## APPLICATION FOR PROPOSED ABLE MARINE ENERGY PARK

**CENTRICA PLC (UNIQUE REFERENCE NUMBER: [REDACTED]), KILLINGHOLME POWER STATION AND ASSOCIATED INFRASTRUCTURE, CHASE HILL ROAD, NORTH KILLINGHOLME AND CENTRICA STORAGE LIMITED, STATION ROAD, NORTH KILLINGHOLME**

## COMMENTS ON ABLE'S RESPONSE TO CENTRICA'S RELEVANT REPRESENTATIONS

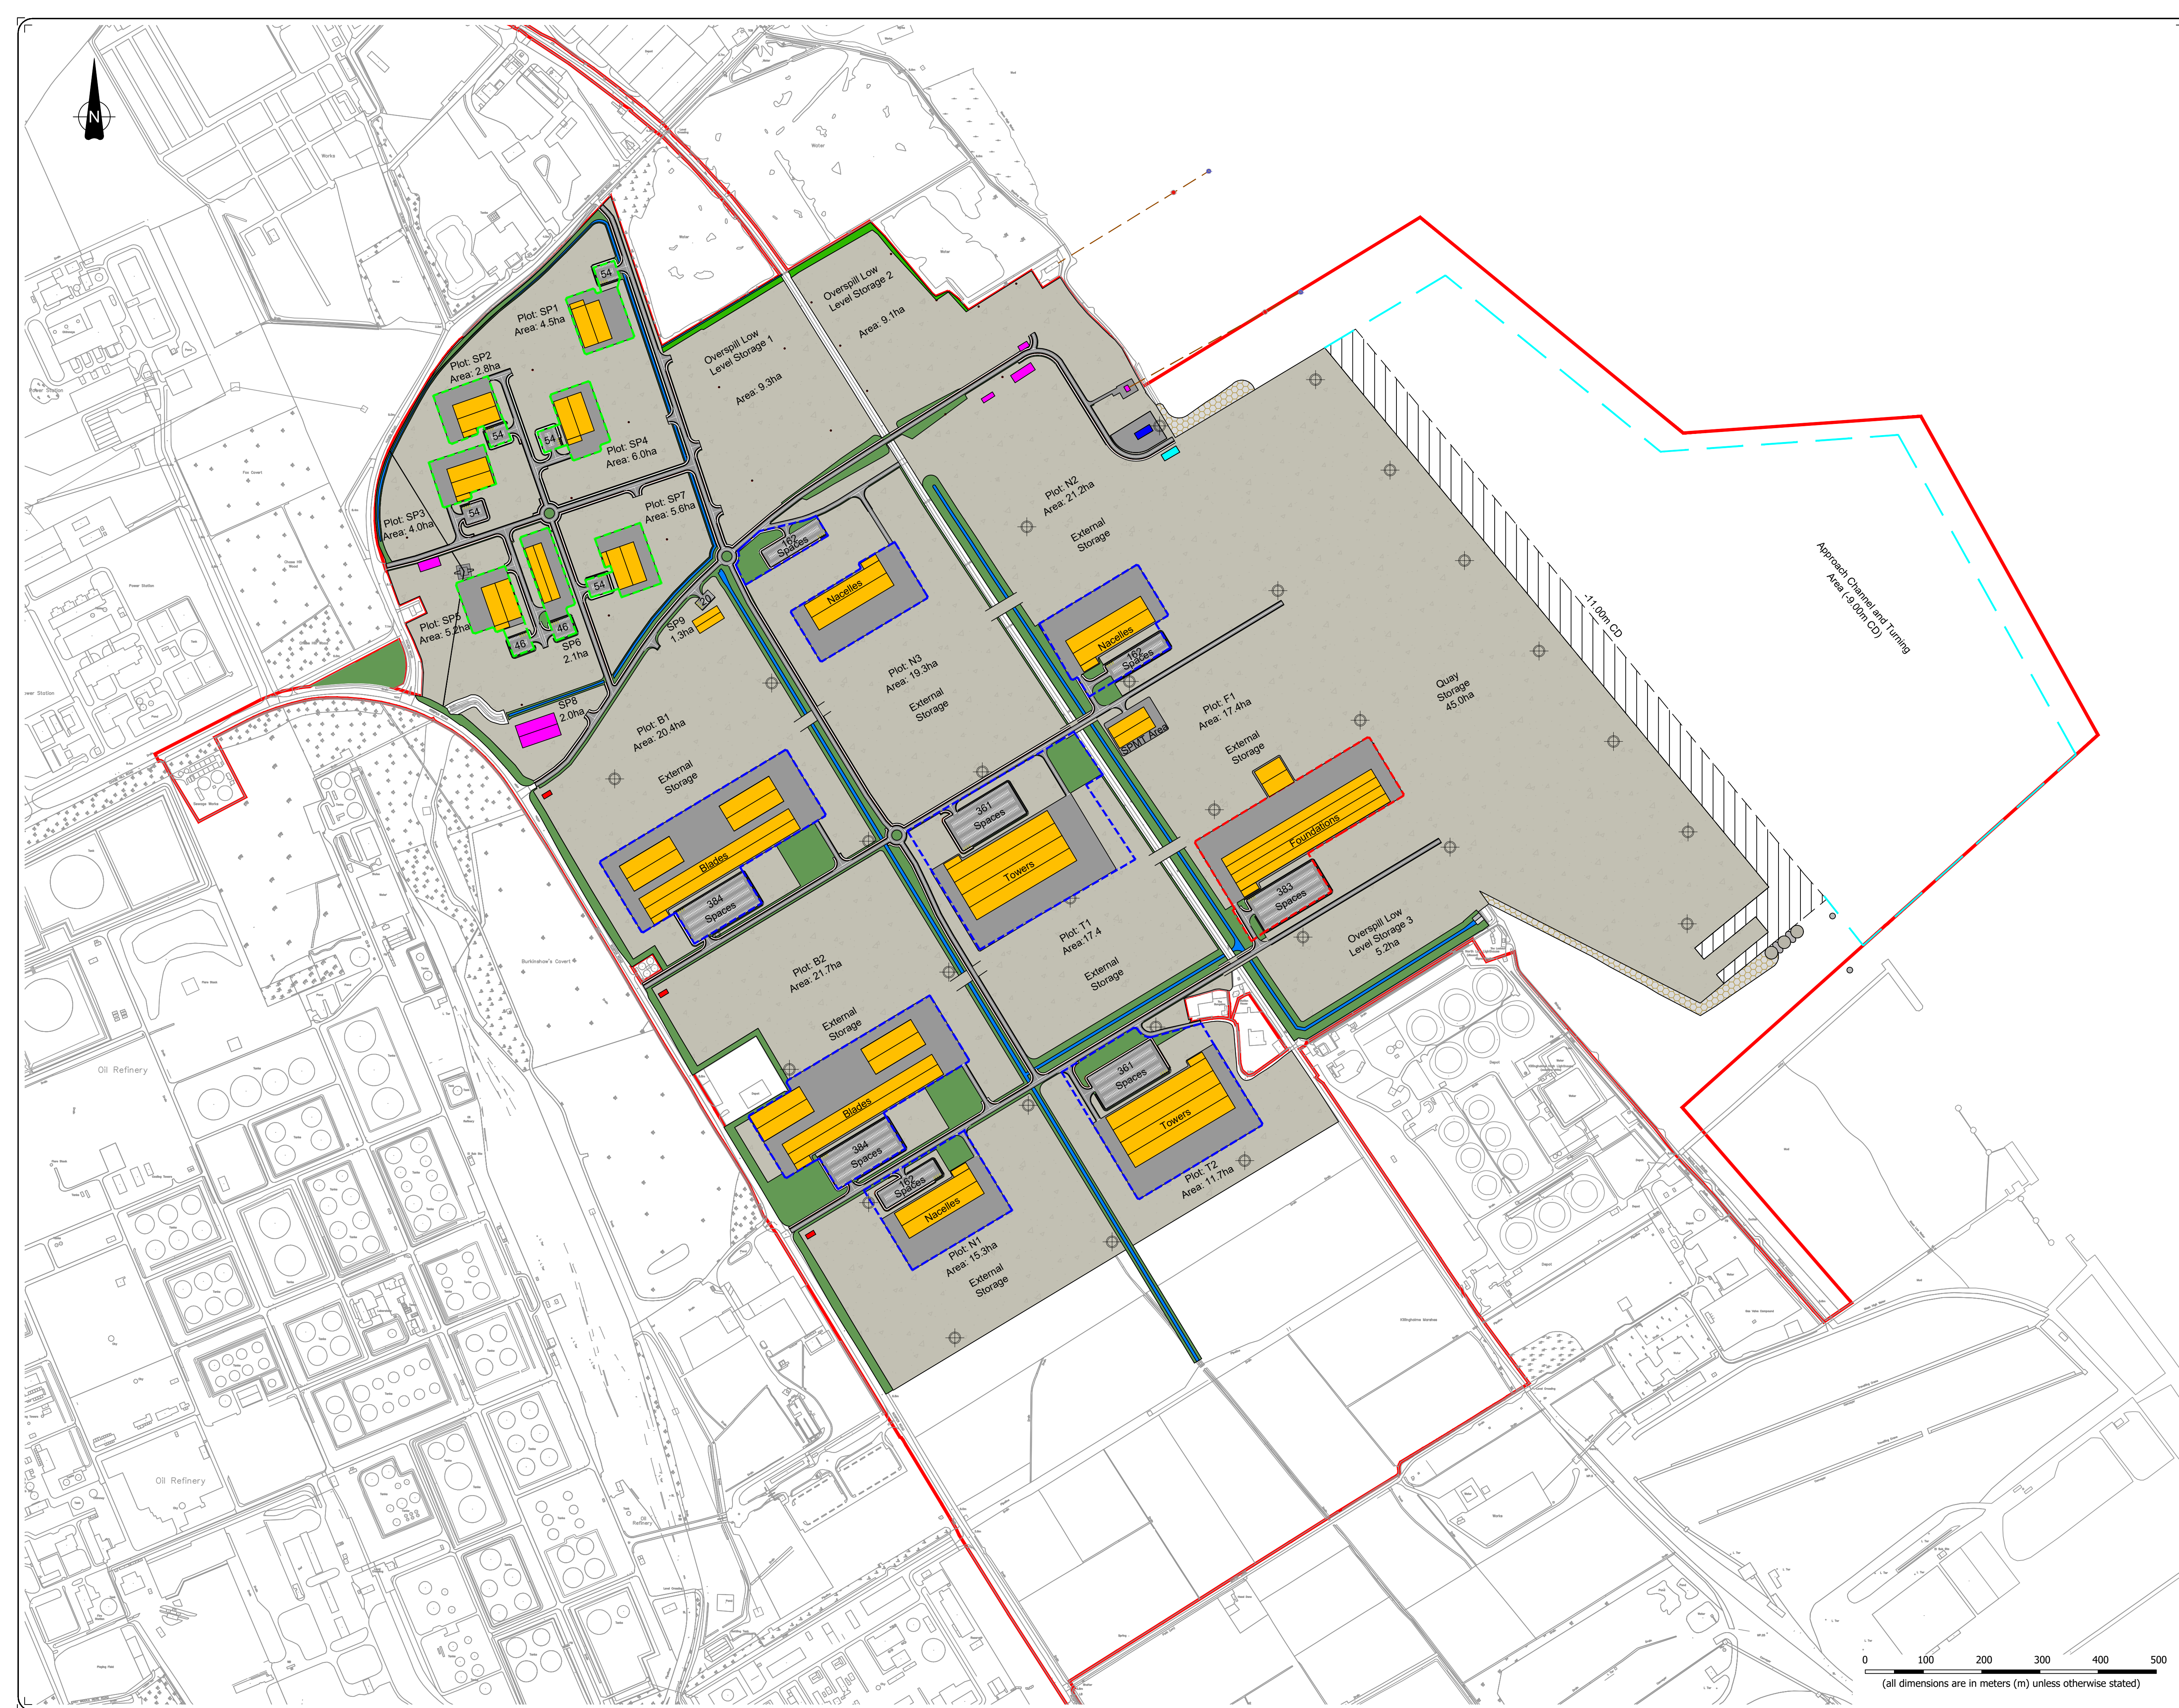
Of particular concern to Centrica is the easement requirements in relation to its cooling water pipeline which runs across the site. Centrica needs to ensure that it has an easement of sufficient width to allow it use, repair, maintain, replace and where necessary, add to this pipeline. Centrica has commissioned Capita Symonds to undertake a study to identify the width of any easement required across the site for this purpose. The report (a copy of which is enclosed for your information) concludes that Centrica would require an easement with a minimum width of 31.7 m. This would provide sufficient space for Centrica to undertake repairs to the pipeline, including its replacement if required, whilst meeting Health and Safety requirements.

E.ON has undertaken a similar assessment of the width of an easement corridor it requires. This assessment identified that the 12.5 m wide easement corridor proposed by Able would not be wide enough for E.ON to undertake any future intrusive works on its pipelines and an easement width of 32.5 m would be required.
